August 24, 2018

Re: MMC Staff Parking Garage | 222 St. John Street | Level III Site Plan  
Response to Public Comments 2

Thank you for coordinating the review of the Maine Medical Center Parking Garage project located at 222 St. John Street. This letter provides a summation of our responses to the comments received from various reviewers as part of the Level III Site Plan process. We have repeated the original comments in italics below, and our response follows each.

C-202
9/17/18

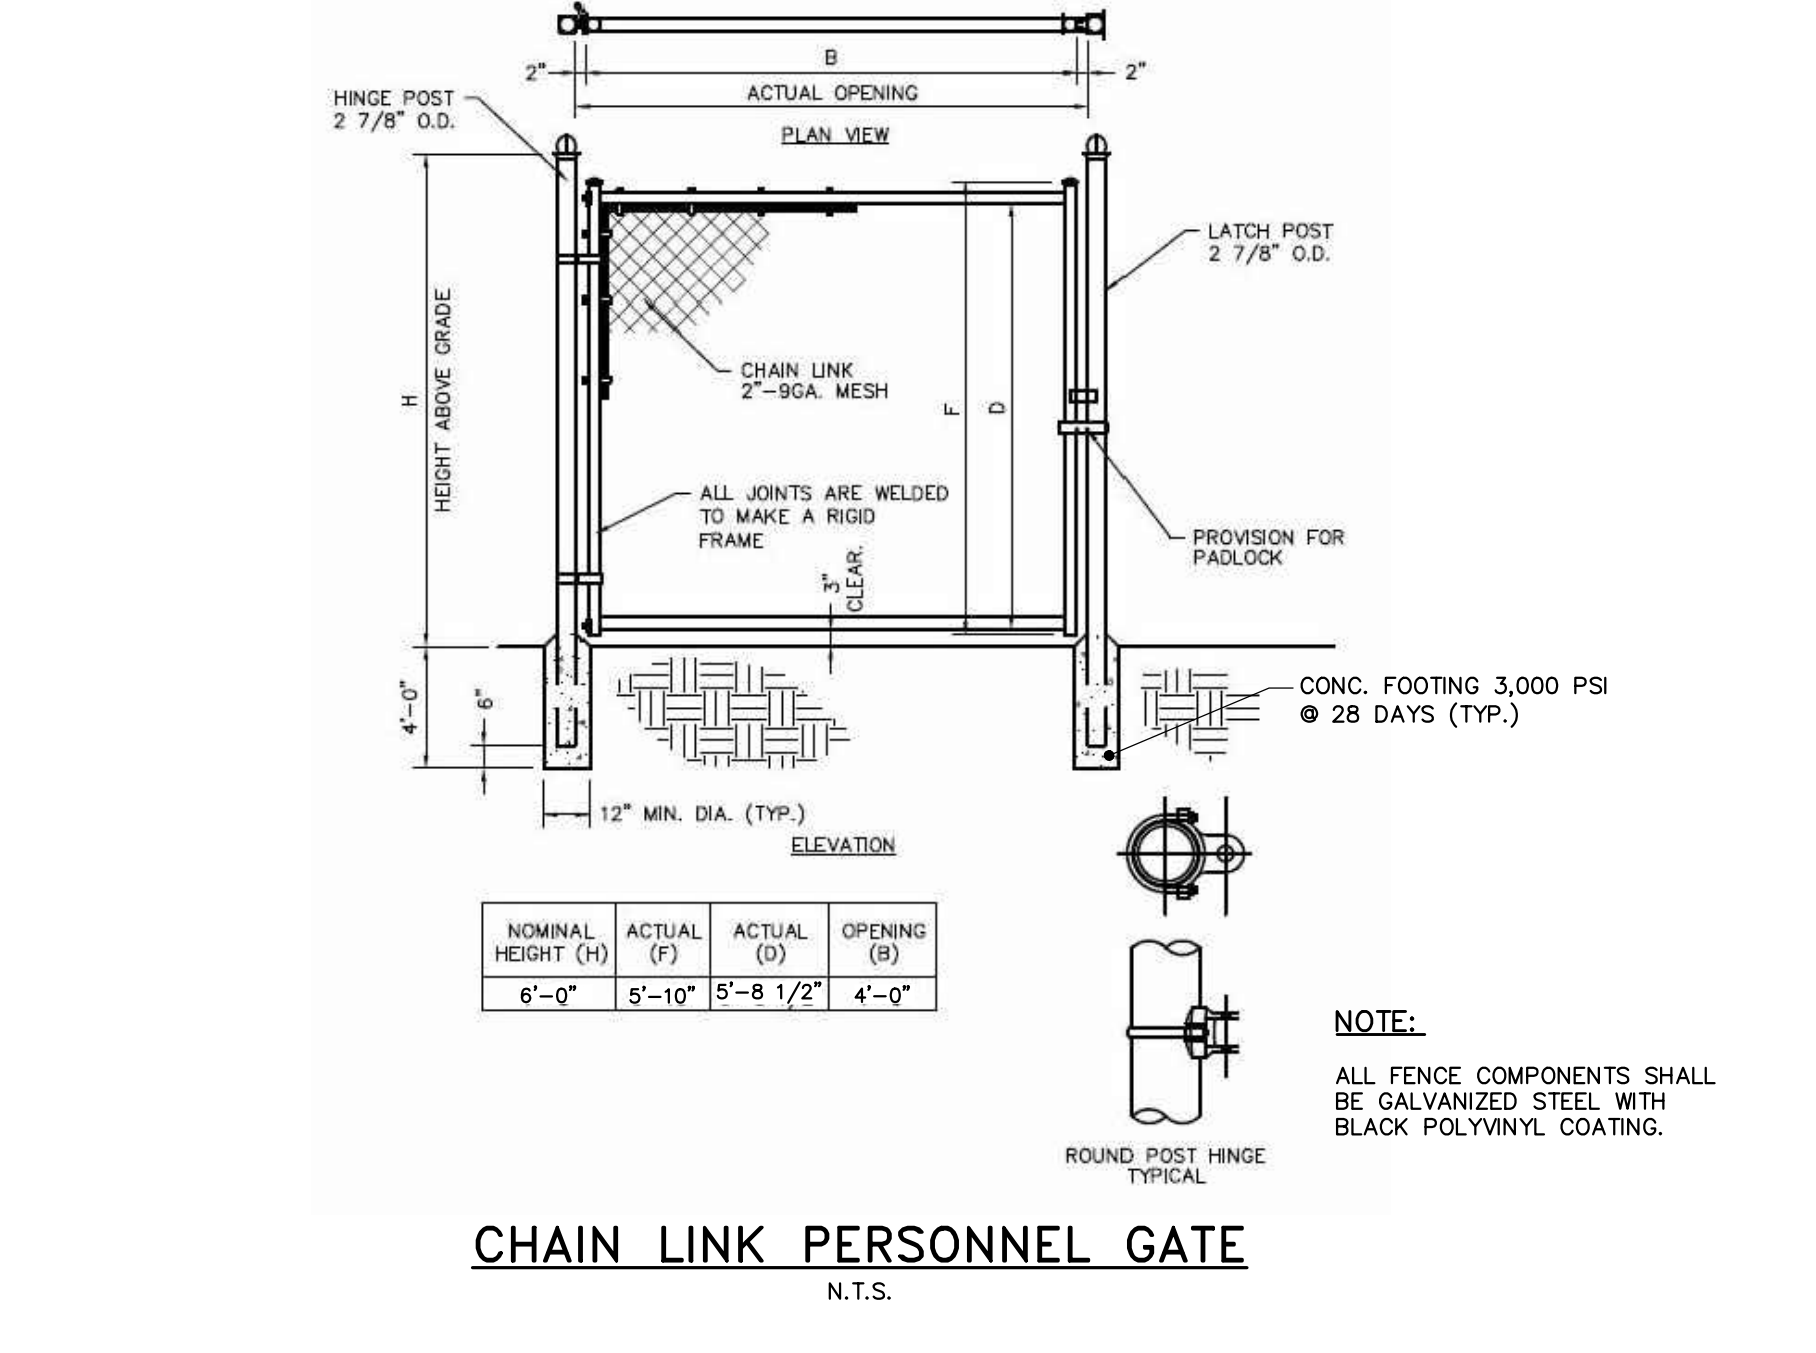
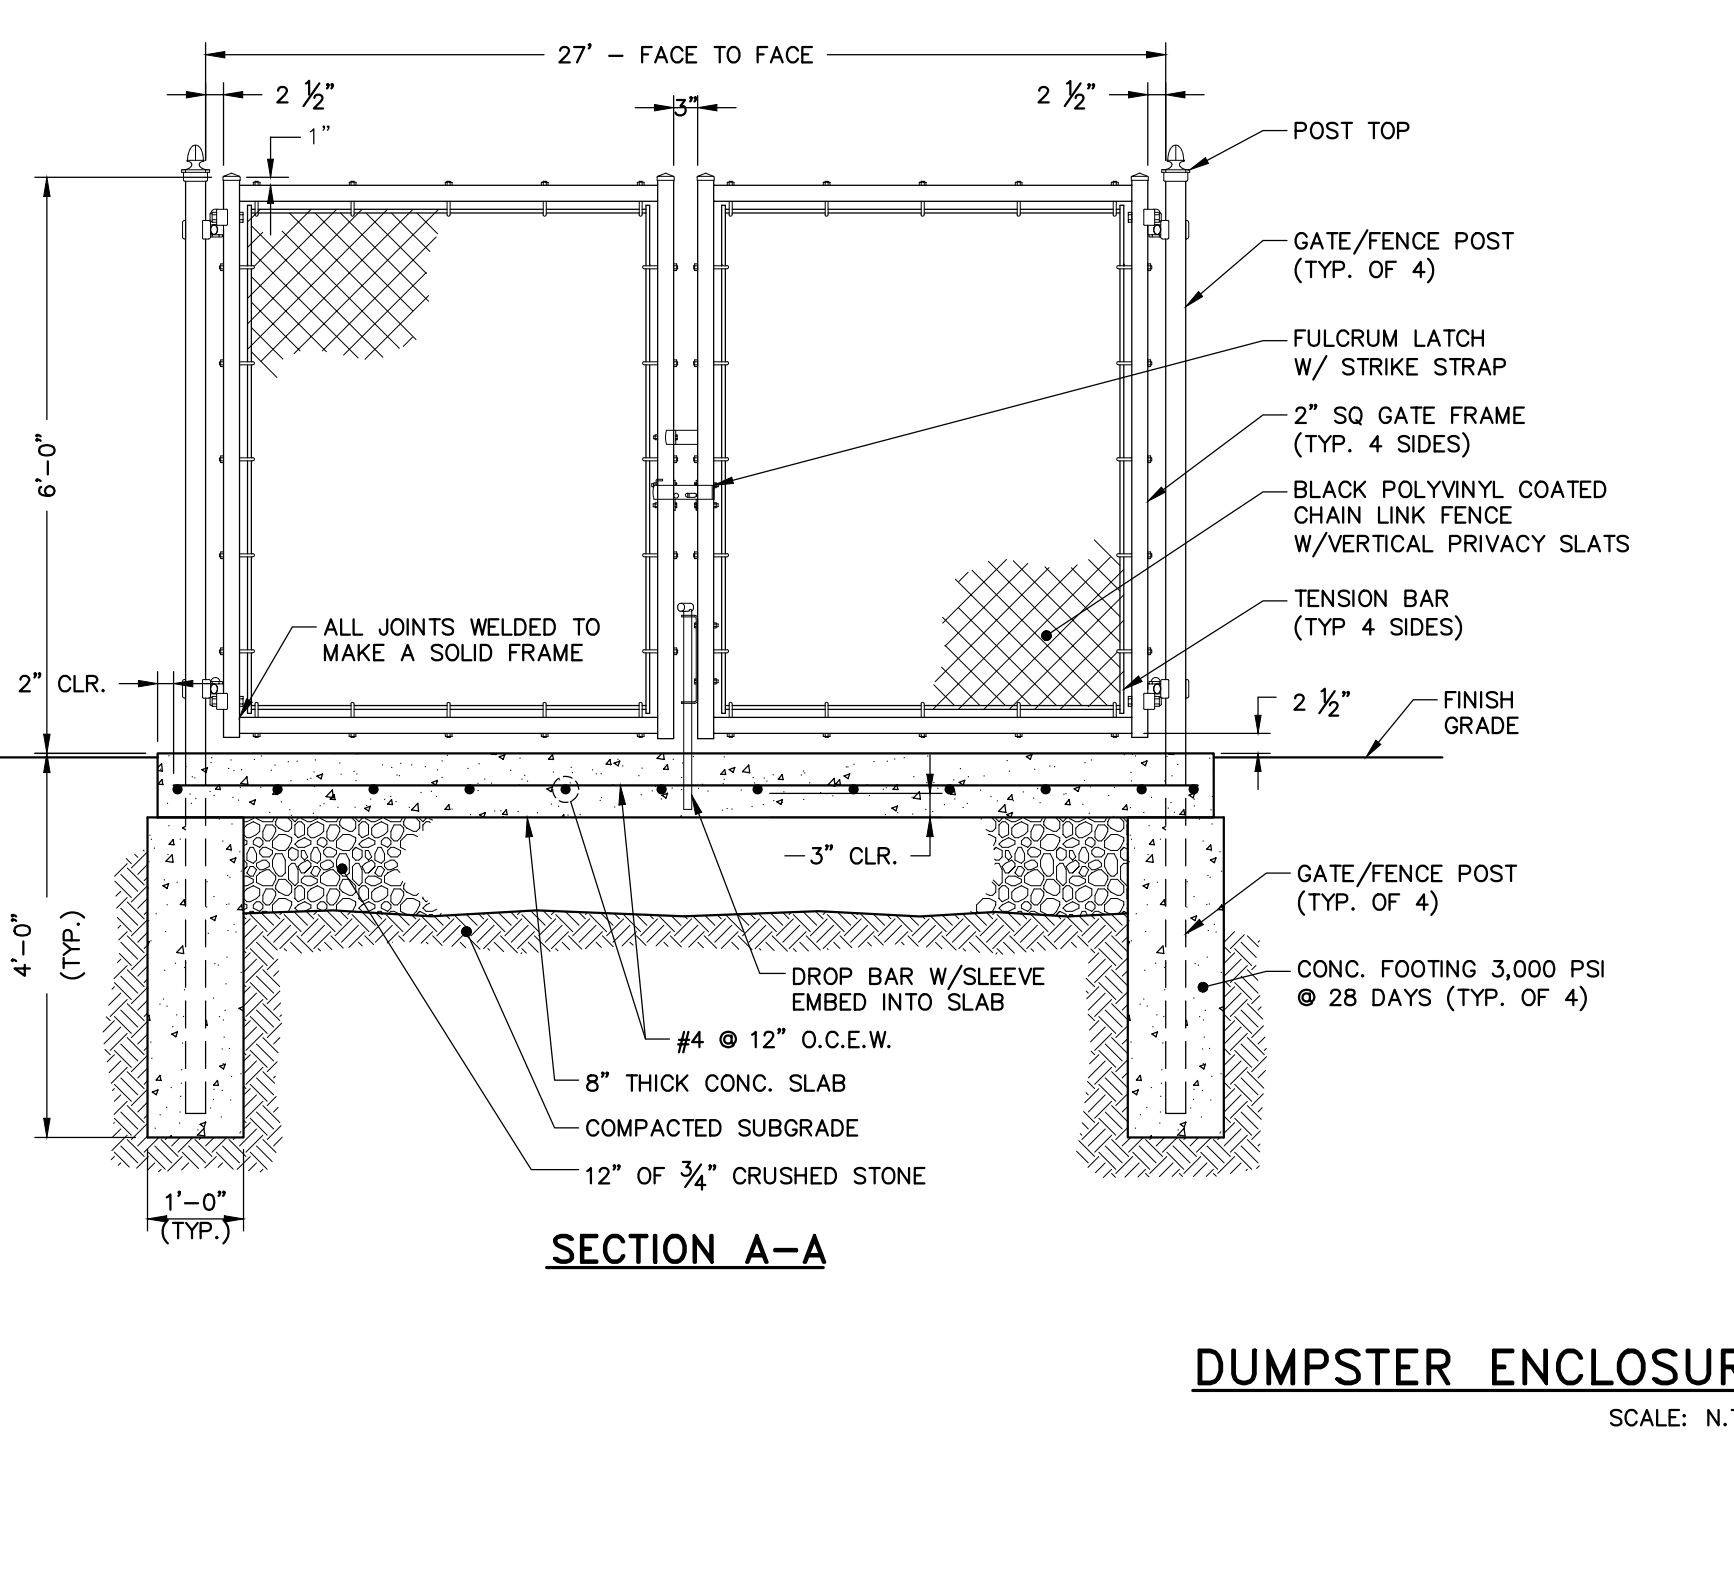
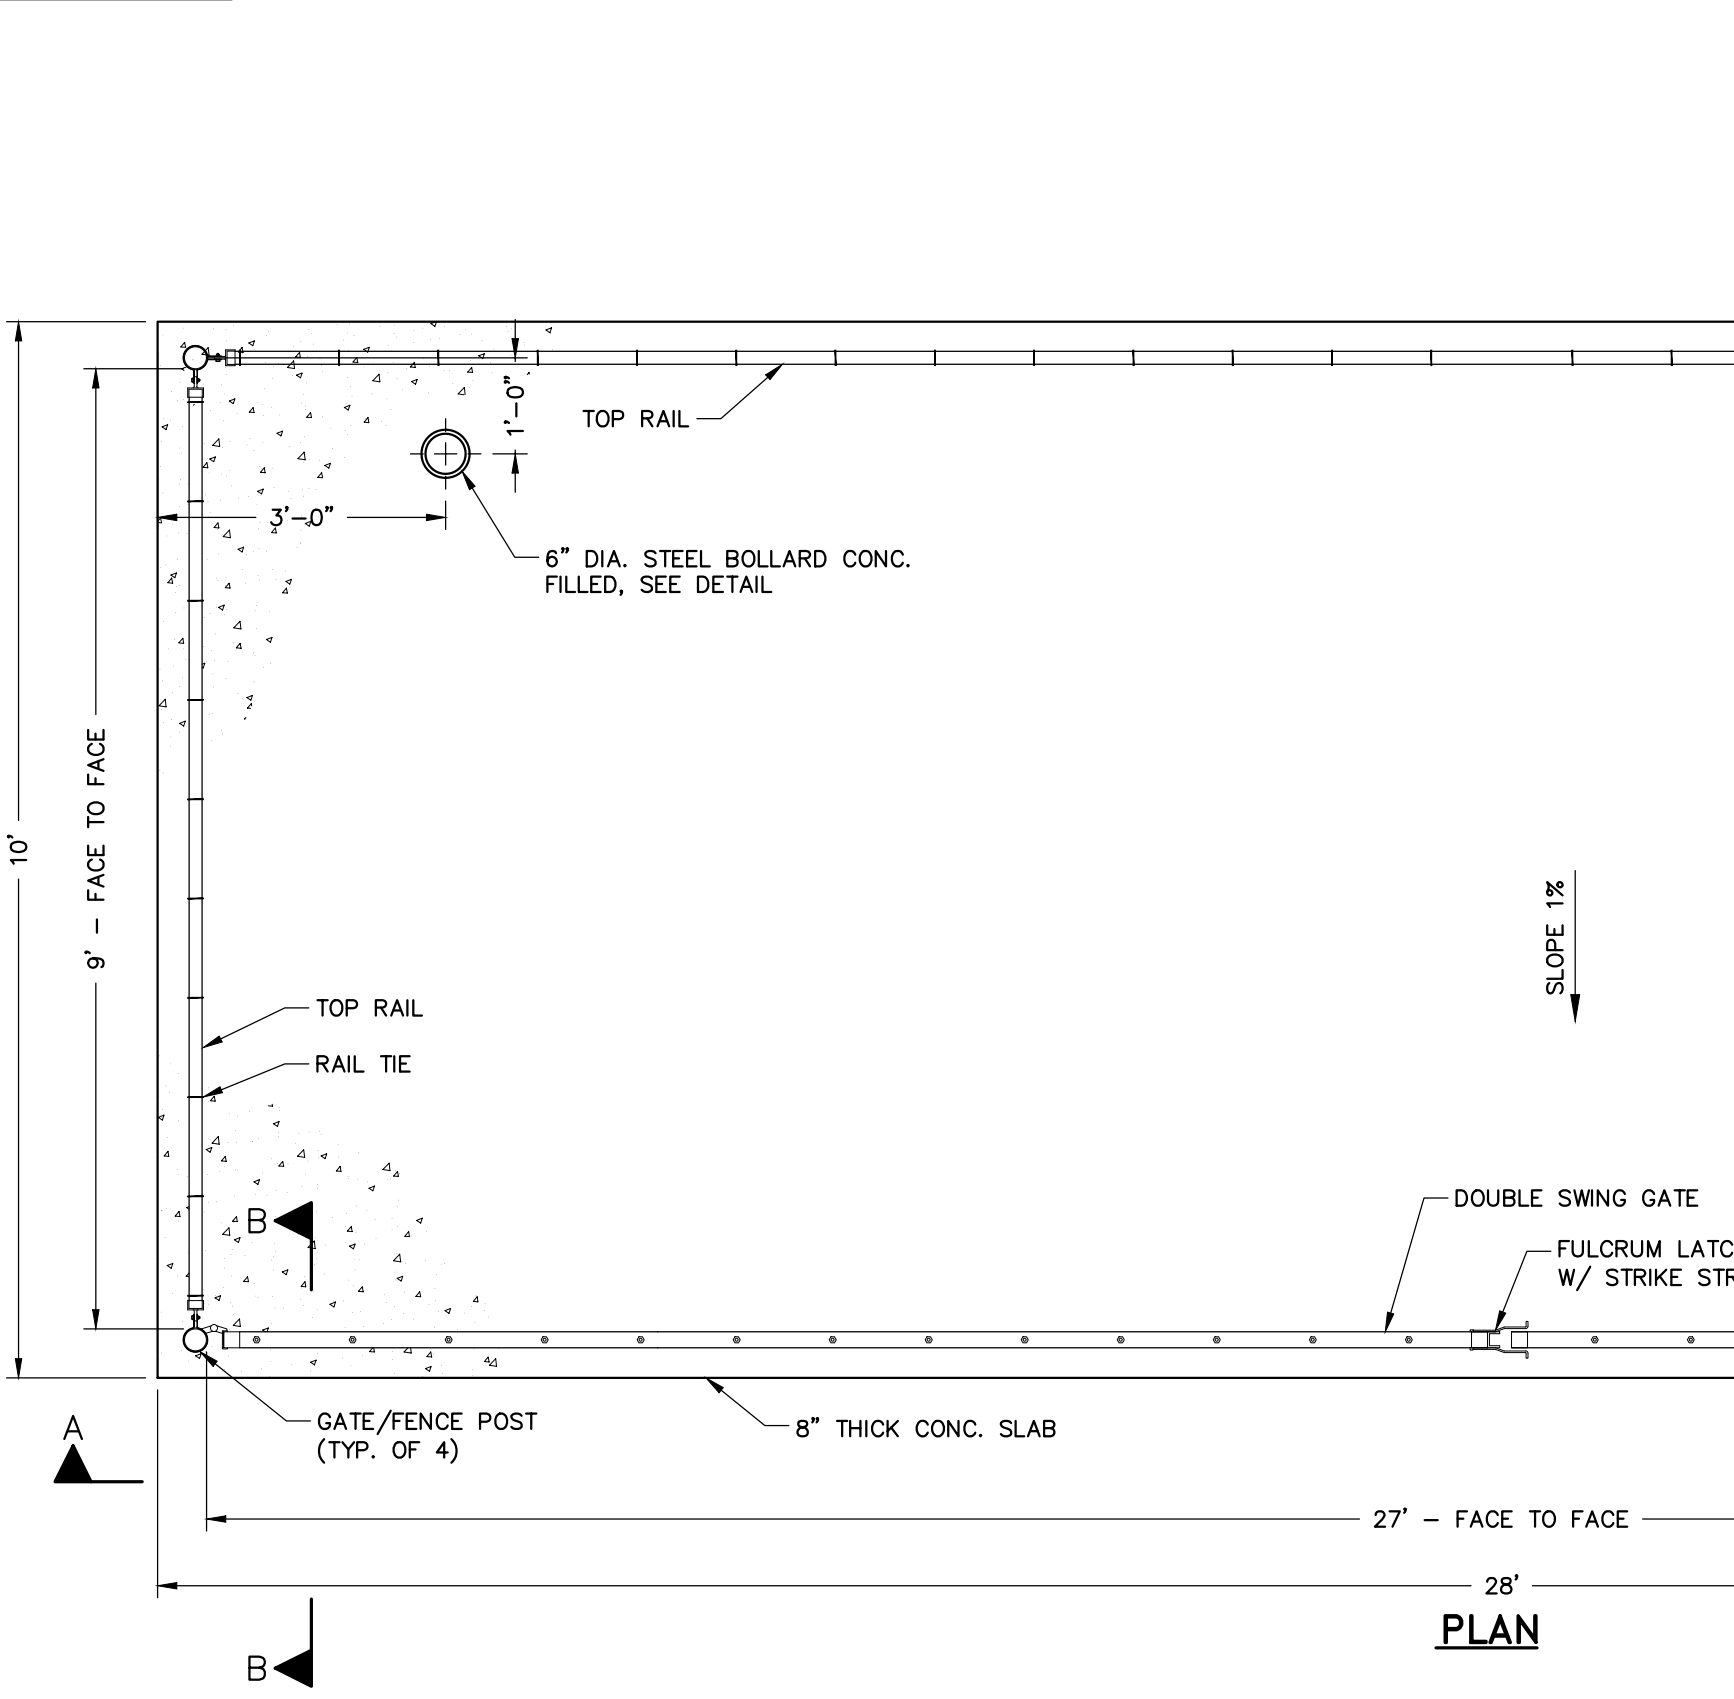
d. *Much of the proposed stormdrain has between 4 feet and 3 feet of cover. Detail on C-202 indicates rigid insulation shall be provided in these locations. No further action is necessary*

**Response:** Comment acknowledged.
